From: Bruce Taunton
Sent: 02 July 2012 17:04
To: Anita Gardner
Subject: RE: R/99/12 Amendments to existing dwelling and new boundary walling - 1 Botany Close, Rustington

Bruce,
Please can you advise if the attached structural calculations are satisfactory for the proposed boundary walling which abuts a greensward used by the public. If you need to look at the plans you can borrow the file if necessary, reference R/99/12.
At this stage I can't get the attached information scanned since it isn't printable from our system so I have requested a hard copy.
Thanks
Anita

Boundary wall footing

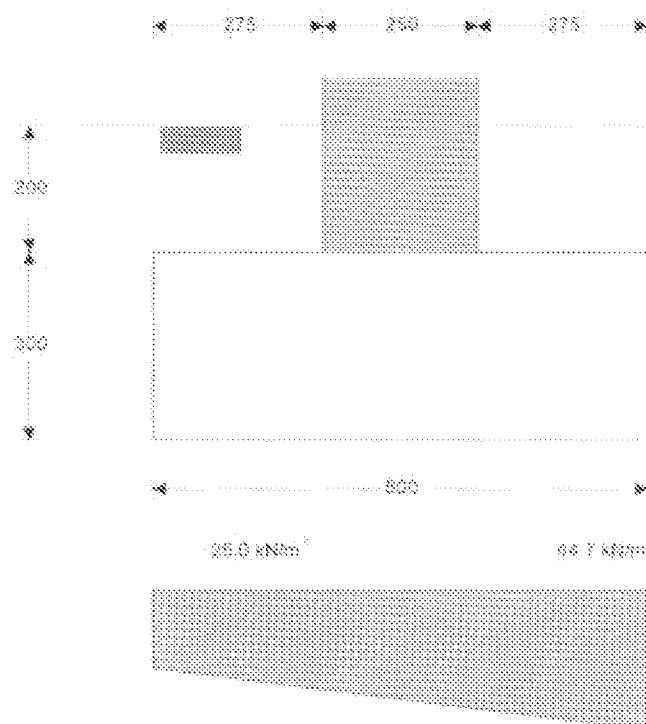
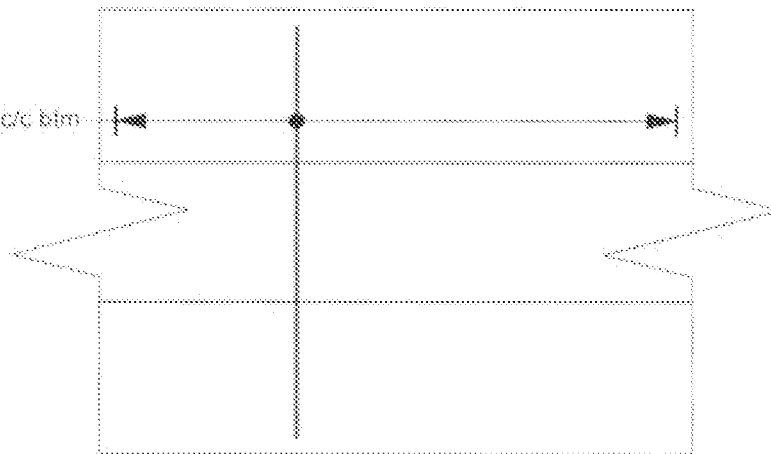
My apologies for not responding sooner. With regards to the proposed wall design calculation, although the allowable soil bearing capacity for the foundation design has been over assumed, the results are within normal tolerances and therefore considered acceptable.
